AL/9/17/DOC

PLAN-017219

Proposal: Application for approval of matters reserved by condition imposed under AL/99/15/PL relating to condition no. 4 (Surface Water Drainage), 5(Landscaping) & 9 (Foul Drainage).

Site: The Gatehouse, Lidsey Road, Aldingbourne, PO20 3ST.
AL/9/17/DOC

project	Residential development The Gatehouse. Lidsey Road. Woodgate		
detail	site levels as proposed		
drawn	sgr	checked	
date	09-15	status	Const.
a1 scale	1:50	a3 scale	1:100
	8590	rev	B

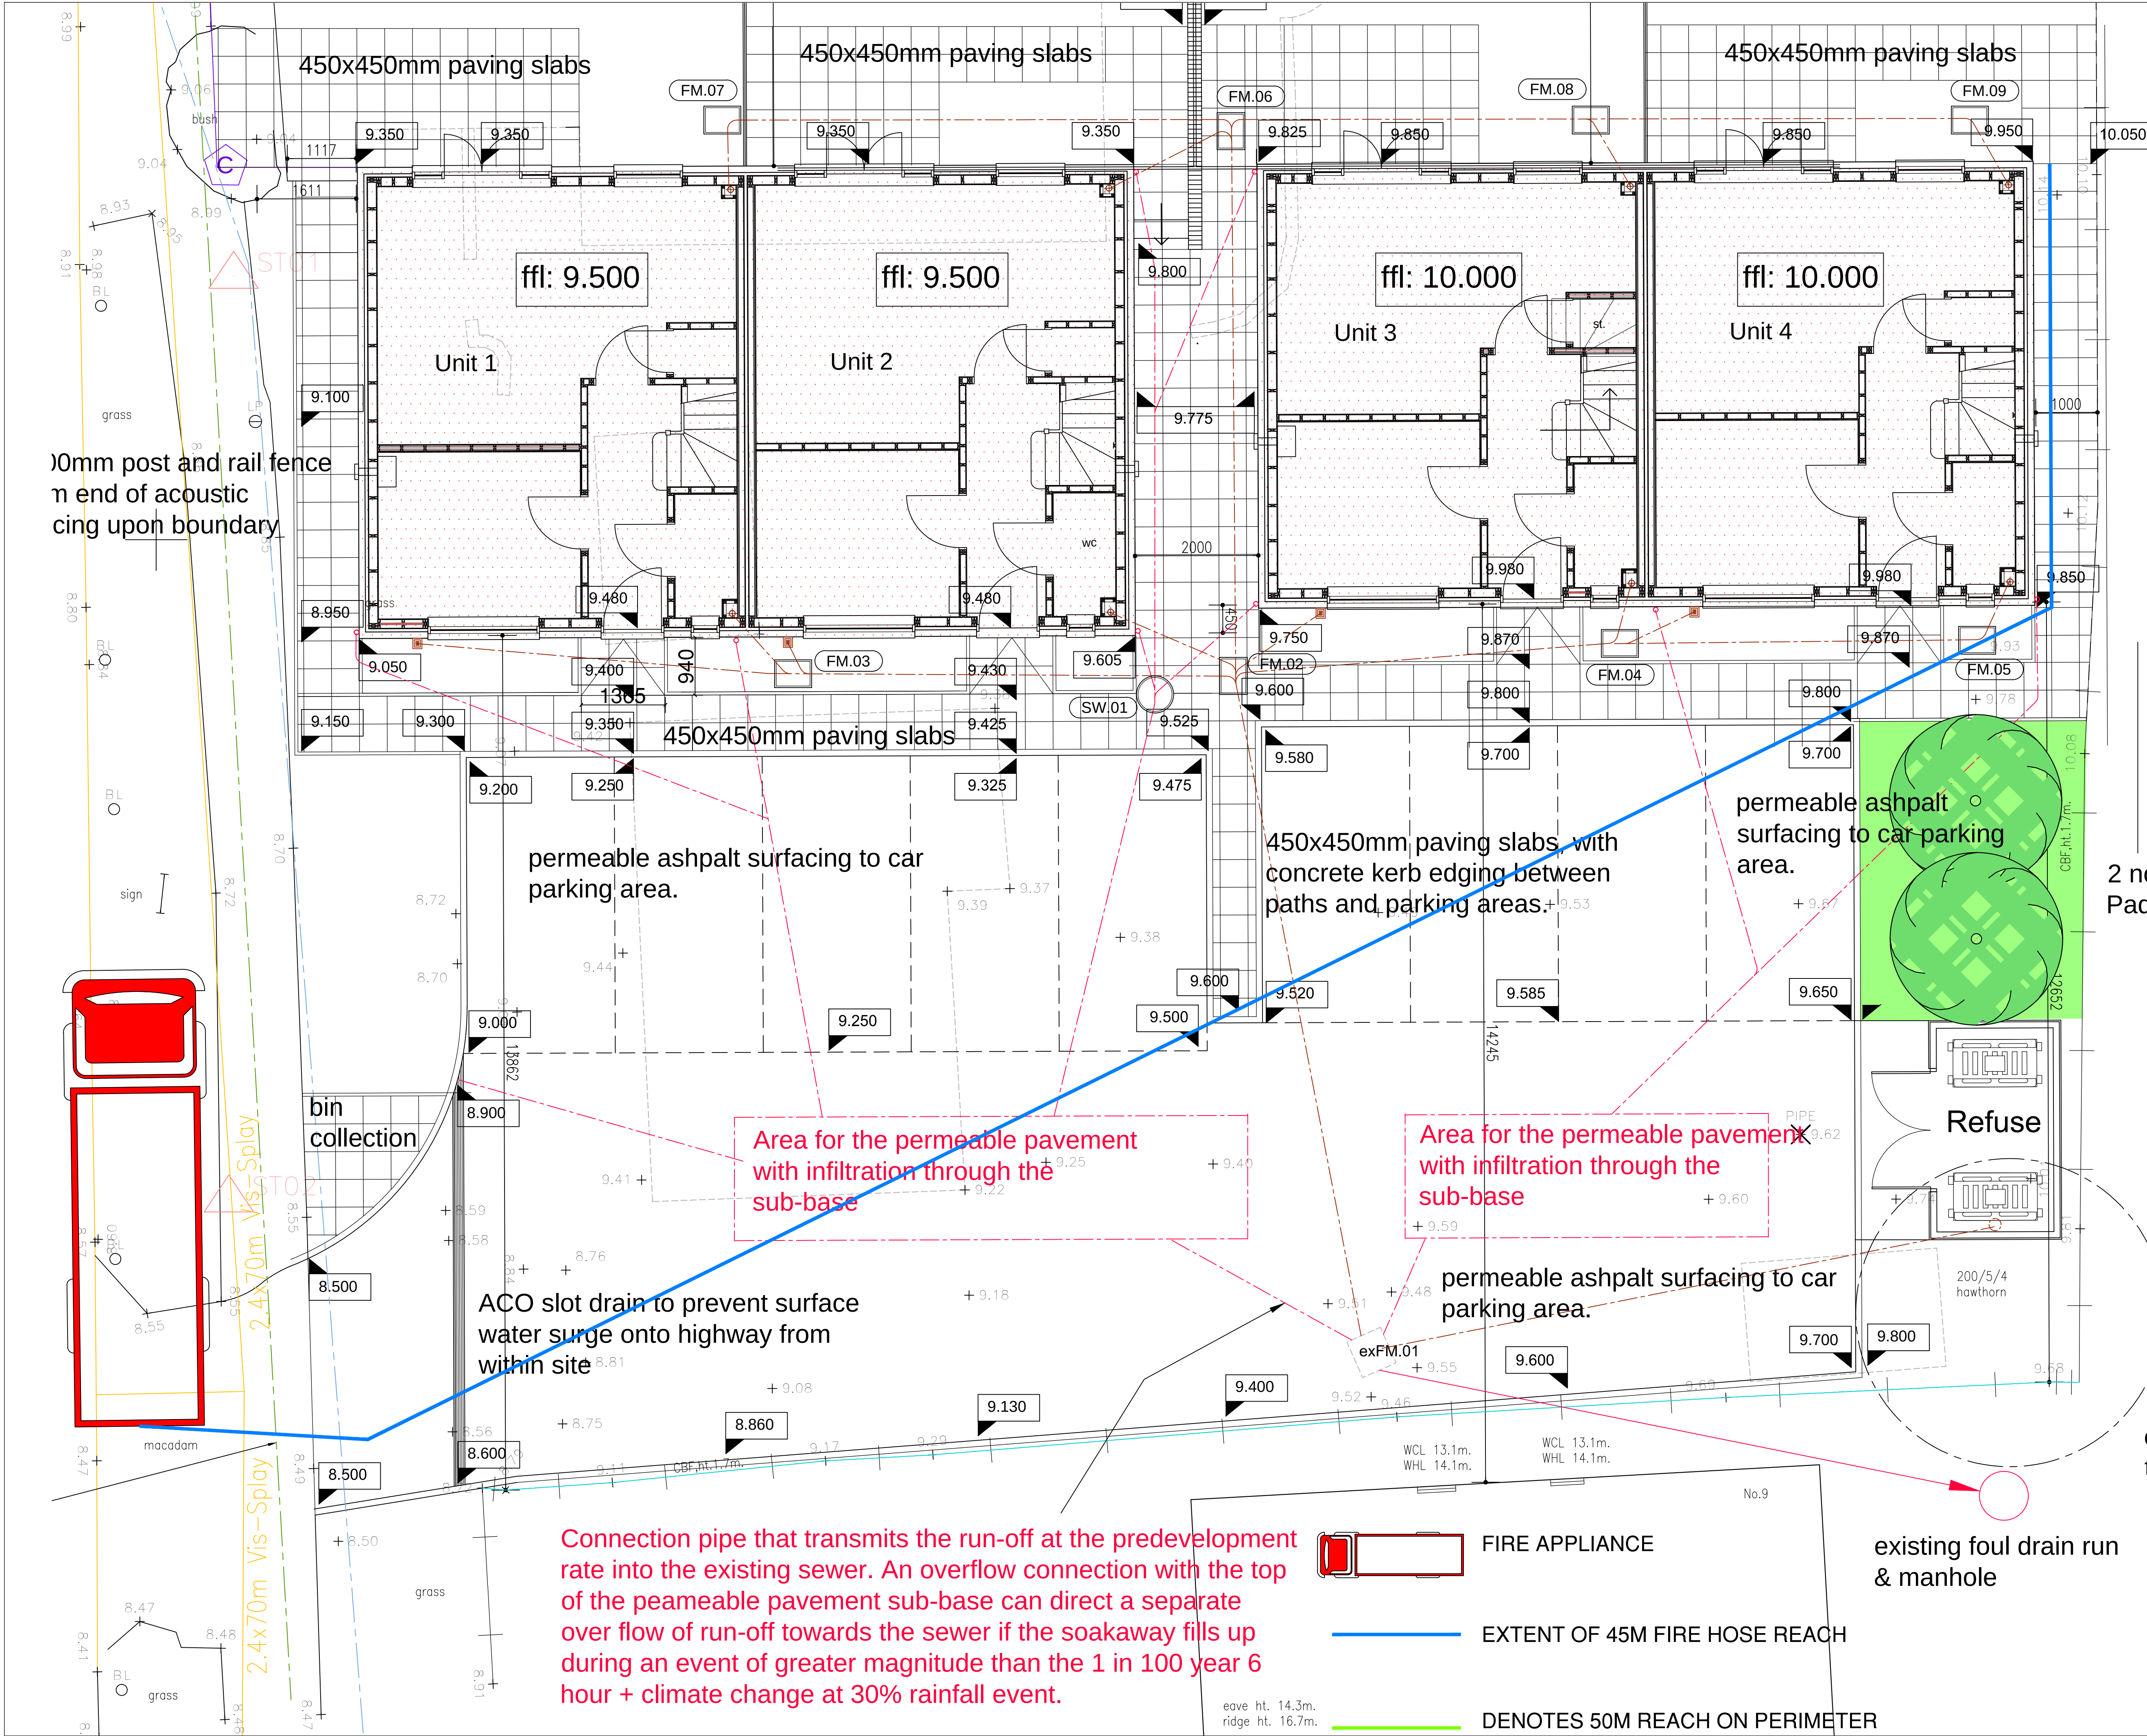
Southern Water would not recommend discharge of condition 4 and 9 relating to drainage. No surface water should be permitted to be discharged to the foul sewerage system, in order to protect properties downstream from flooding.

Please note no ground water or overflow from soakaway is permitted to enter the sewerage network.

It is the responsibility of the developer to make suitable provision for the disposal of surface water. Part H3 of the Building Regulations prioritises the means of surface water disposal in the order

- a Adequate soakaway or infiltration system
- b Water course
- c Where neither of the above is practicable, sewer
